Subject: Major Projects – Response To Submissions - Mixed use development with infill affordable housing, 25 Moss Vale Road Bomaderry (SSD-69257218) (Shoalhaven City)

Attachment A: Detailed floodplain risk management comments – 25 Moss Vale Road Bomaderry

Attachment A: Mixed use development with infill housing - Detailed floodplain risk management comments

Figure 6-1 Climate Change Sensitivity

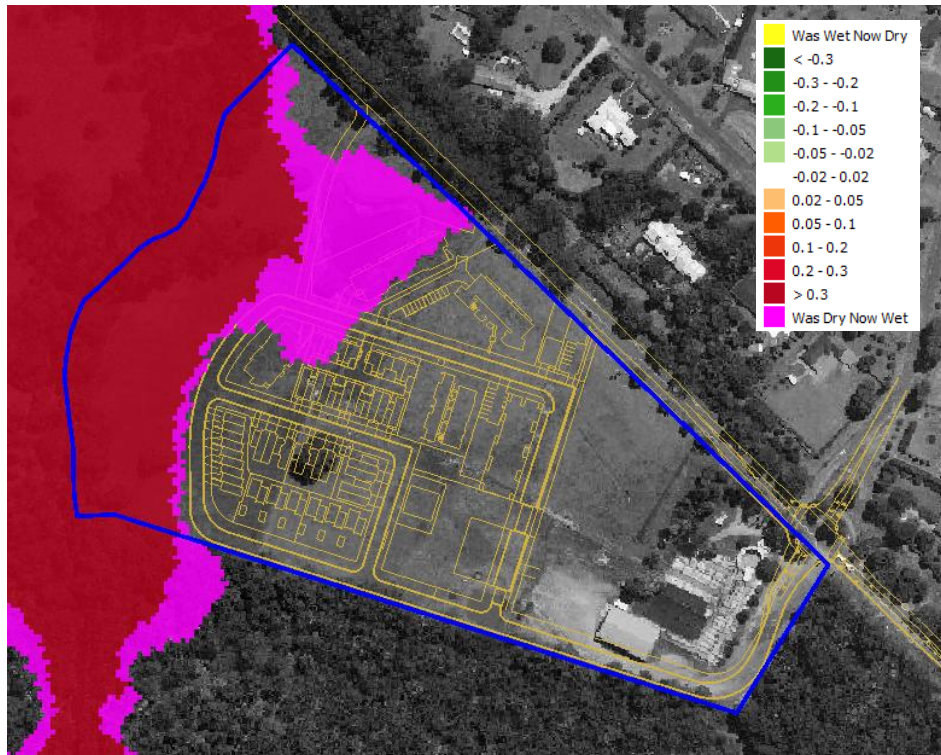
Consideration of the impacts of climate change on development is a requirement of the SEARs, the Local Planning Direction, Council's LEP and DCP. Climate change is a key issue such that flood planning levels address the performance criteria over the anticipated design life of the proposal including understanding the consequences of flooding to residential development proposed on the floodplain. Climate change has been assessed in the FIRA as a sensitivity, but not consistently through the FIRA to understand the potential flood risk. It is unclear if climate change has been considered in the Probable Maximum Flood Event (PMF). The FIRA should consider the impacts of climate change utilising the guidance provided in the Australian Rainfall and Runoff (ARR) Climate Change Consideration Chapter, noting this also applies to the PMF event.

Flood Impact (Developed minus Existing) PMF

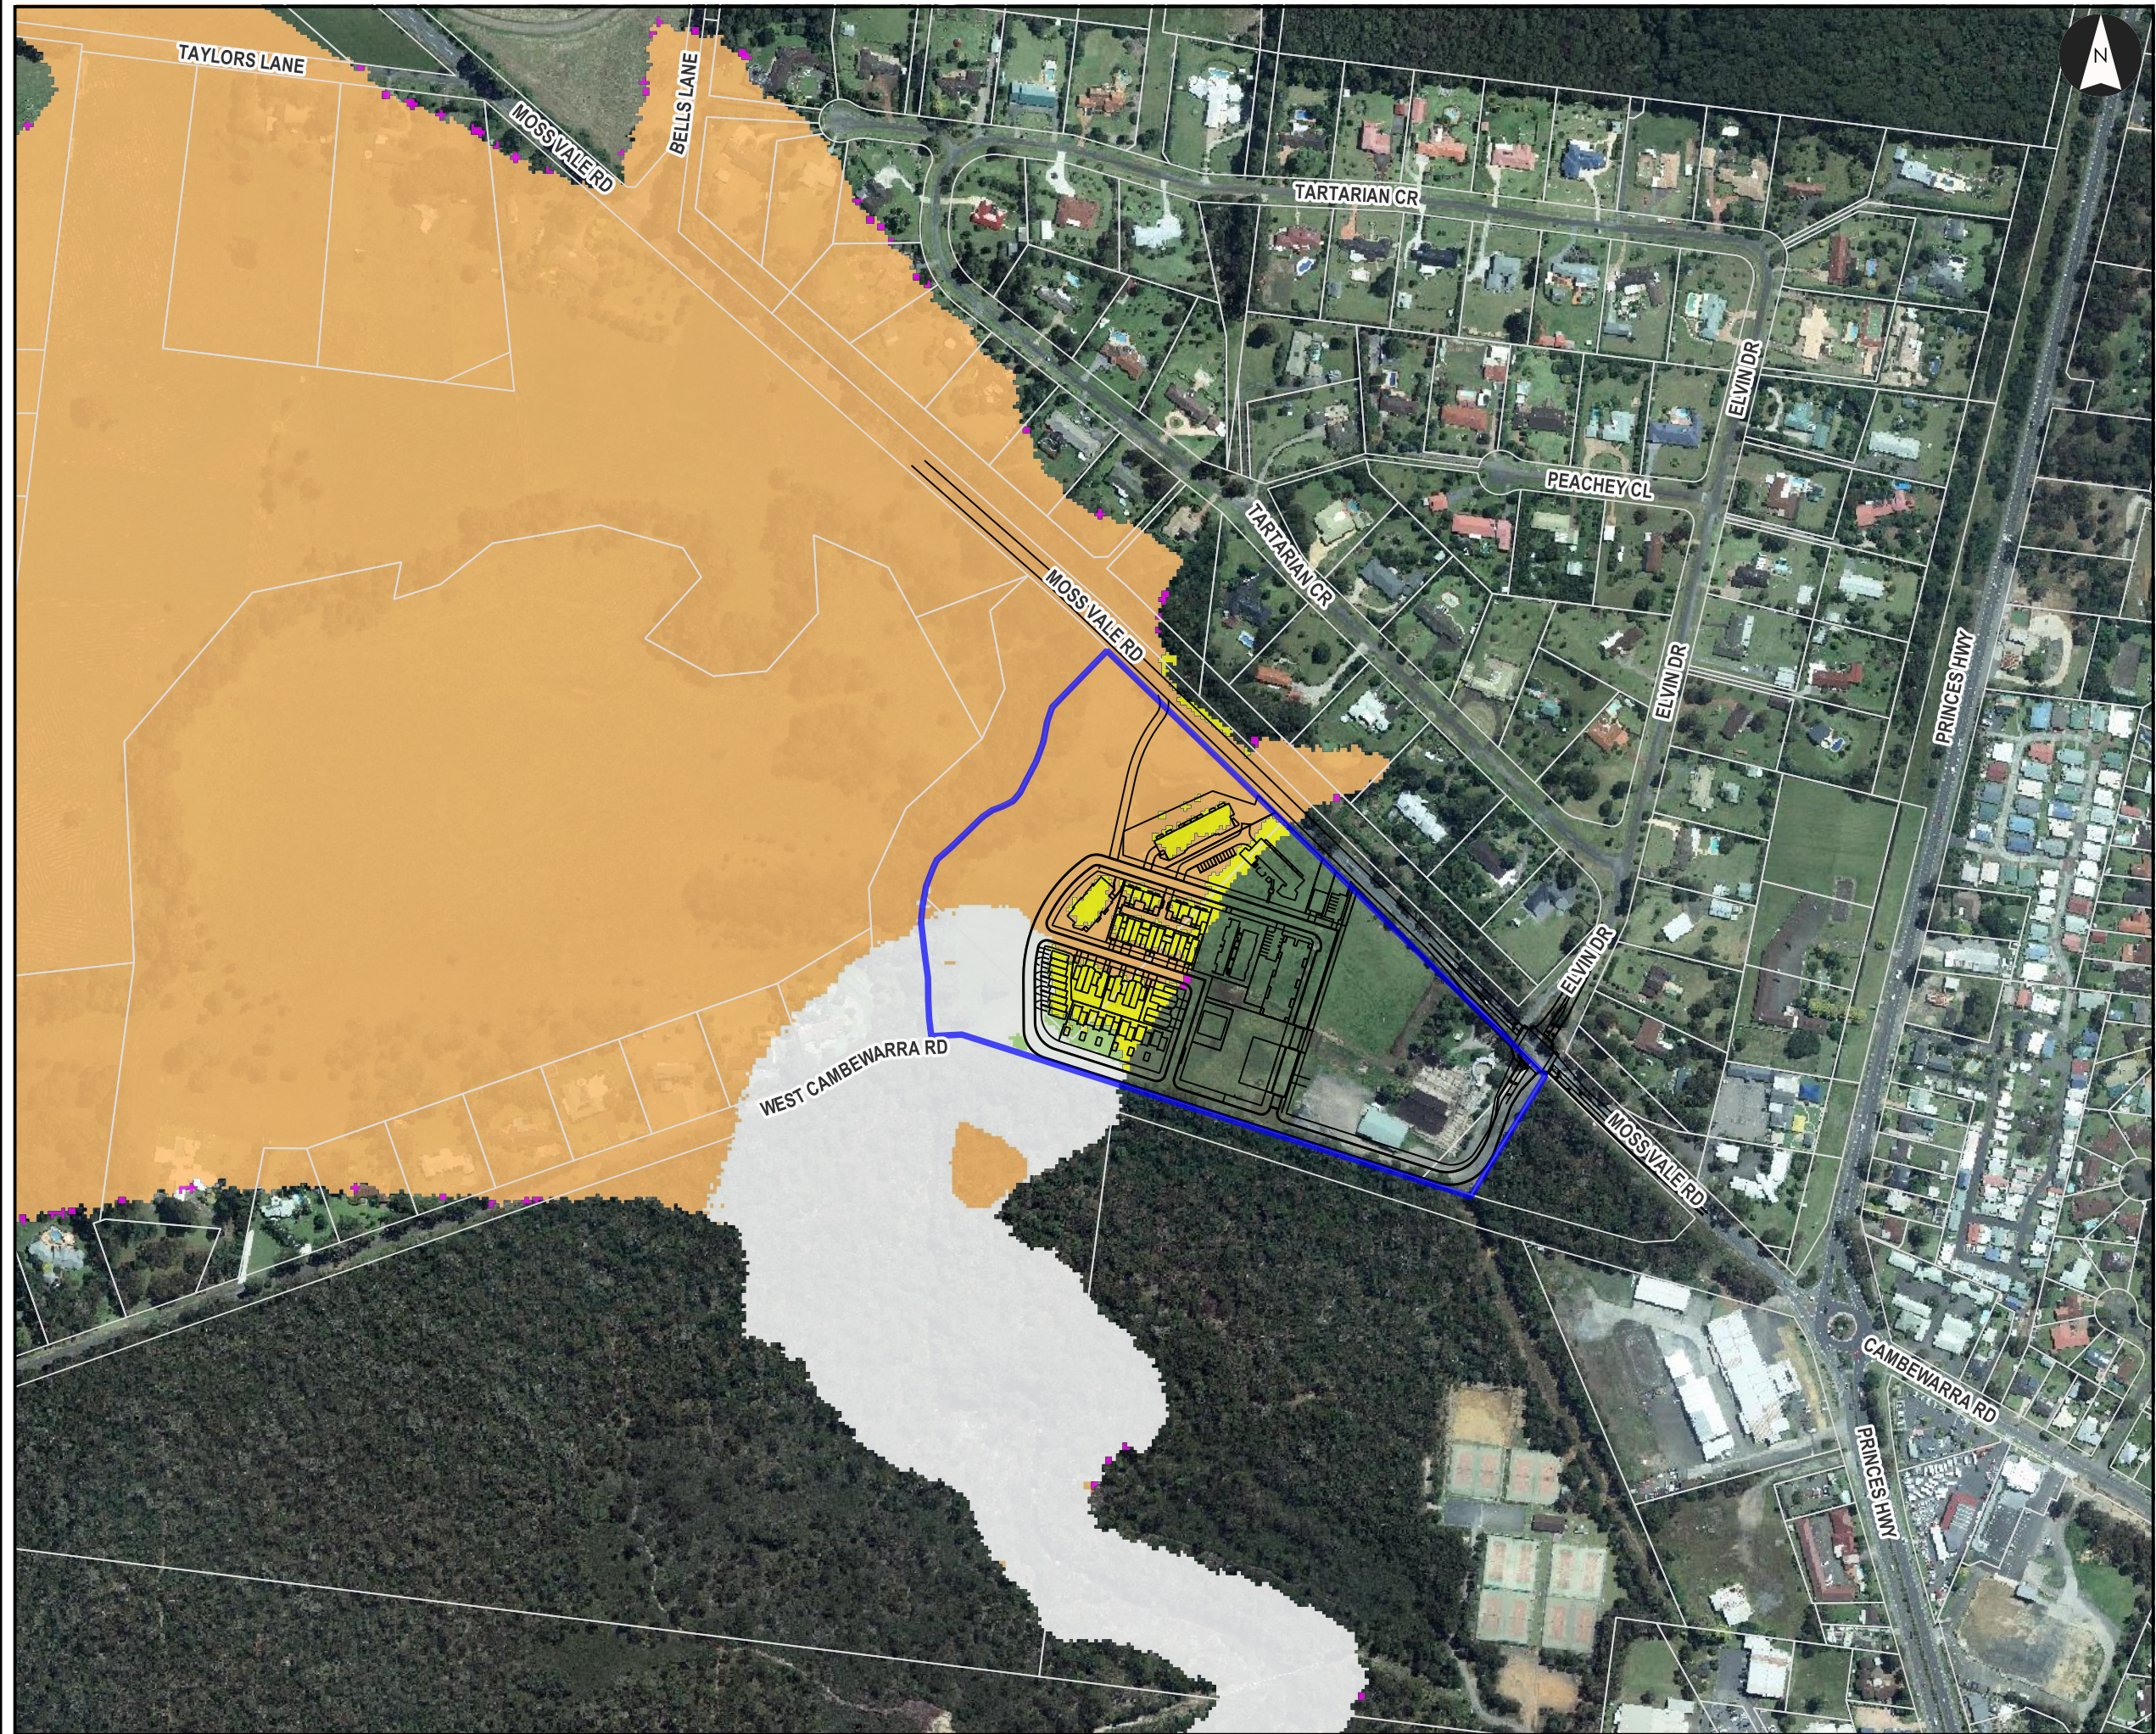
The FIRA should demonstrate that the development does not result in adverse impacts to flood behaviour across the full range of flood events considering flood levels, velocities, hazards, categories and duration. The FIRA demonstrates that extensive flood impacts will occur in the PMF event including to existing residential development. These impacts are caused by filling in the floodplain and measures to mitigate these impacts have not been explored in the FIRA.
